WILDFIRE PROTECTION PLAN

**CRYSTAL PARK SITE # S-160(VR)
ADD TO CRYSTAL PARK, SUB NO2,
MANITOU SPRINGS, CO 80829**

**DEVELOPED FOR
COLE JOLLY, OWNER**

**Revised March 13, 2026
Submitted to
El Paso County Land Use Office, the Crystal Park Fire Department and
the Crystal Park Architectural Control Committee**

SITE PLAN

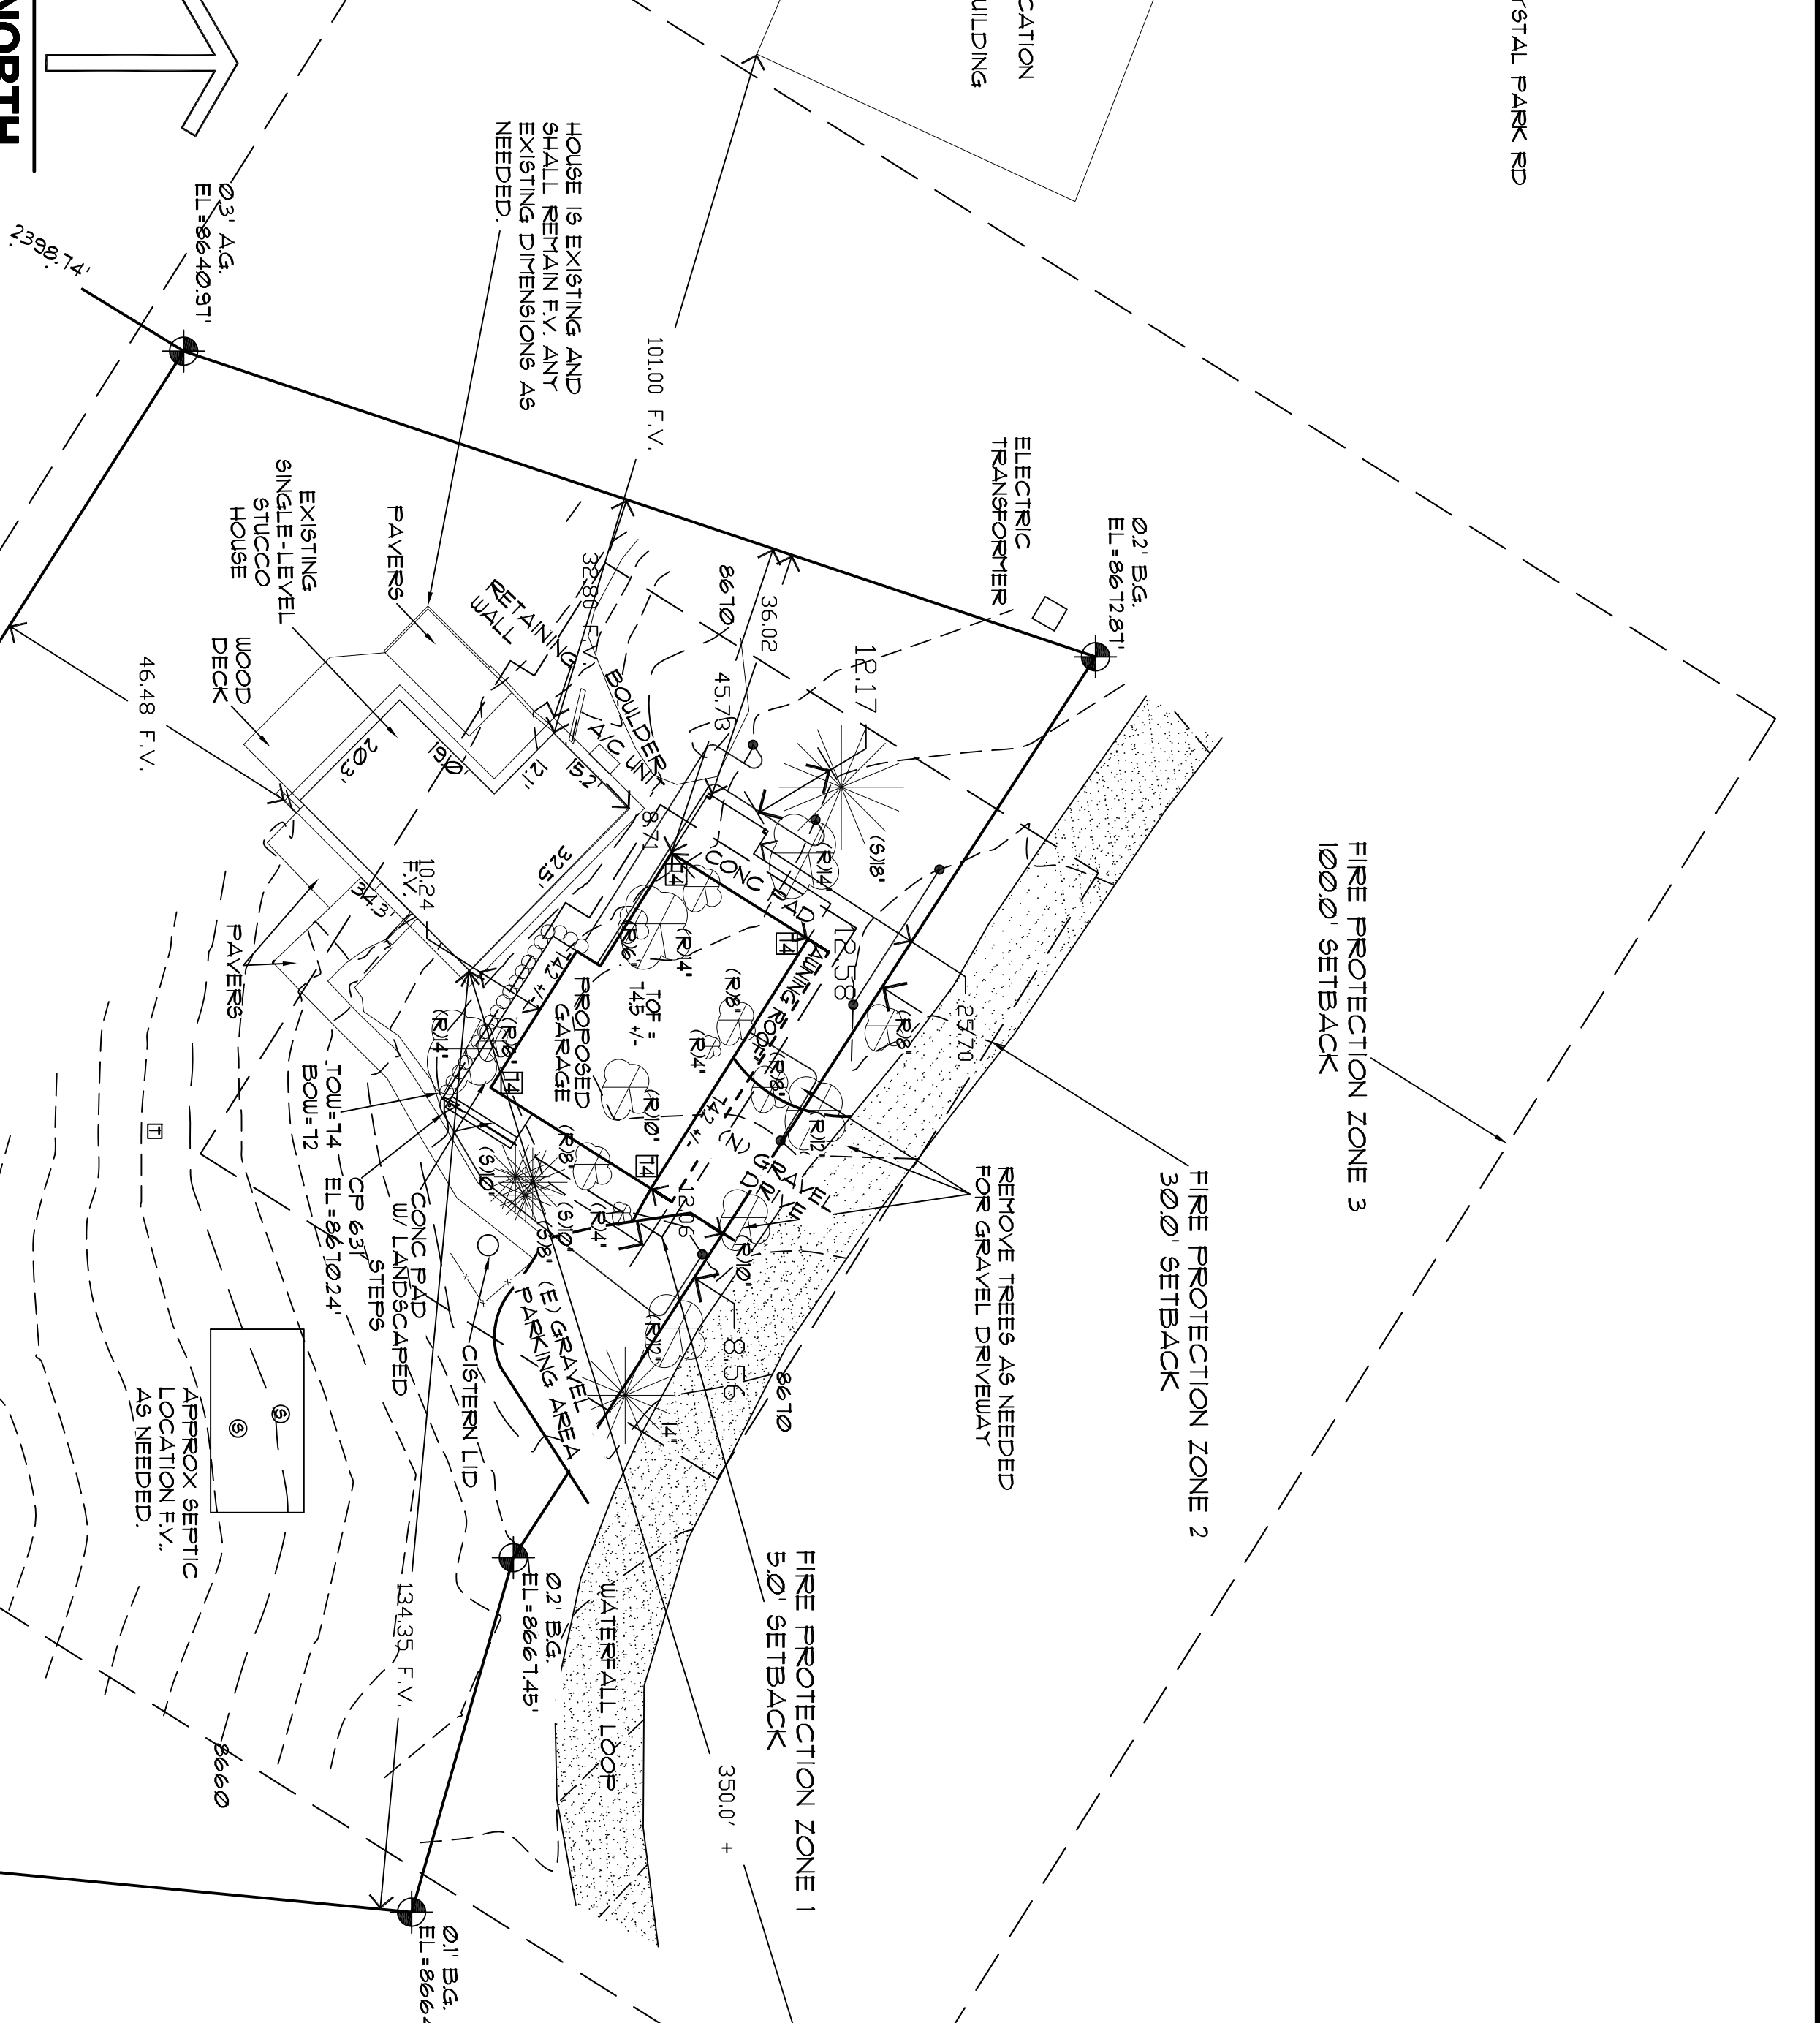
I don't see any of these items on the two screen shots below.

Per previous comment:

Section 6.3.3 (D)(2)(a) of the Land Development Code requires that wildland fire risk and hazard mitigation plans shall be prepared by qualified professionals. Please see the memo at the end of this document.
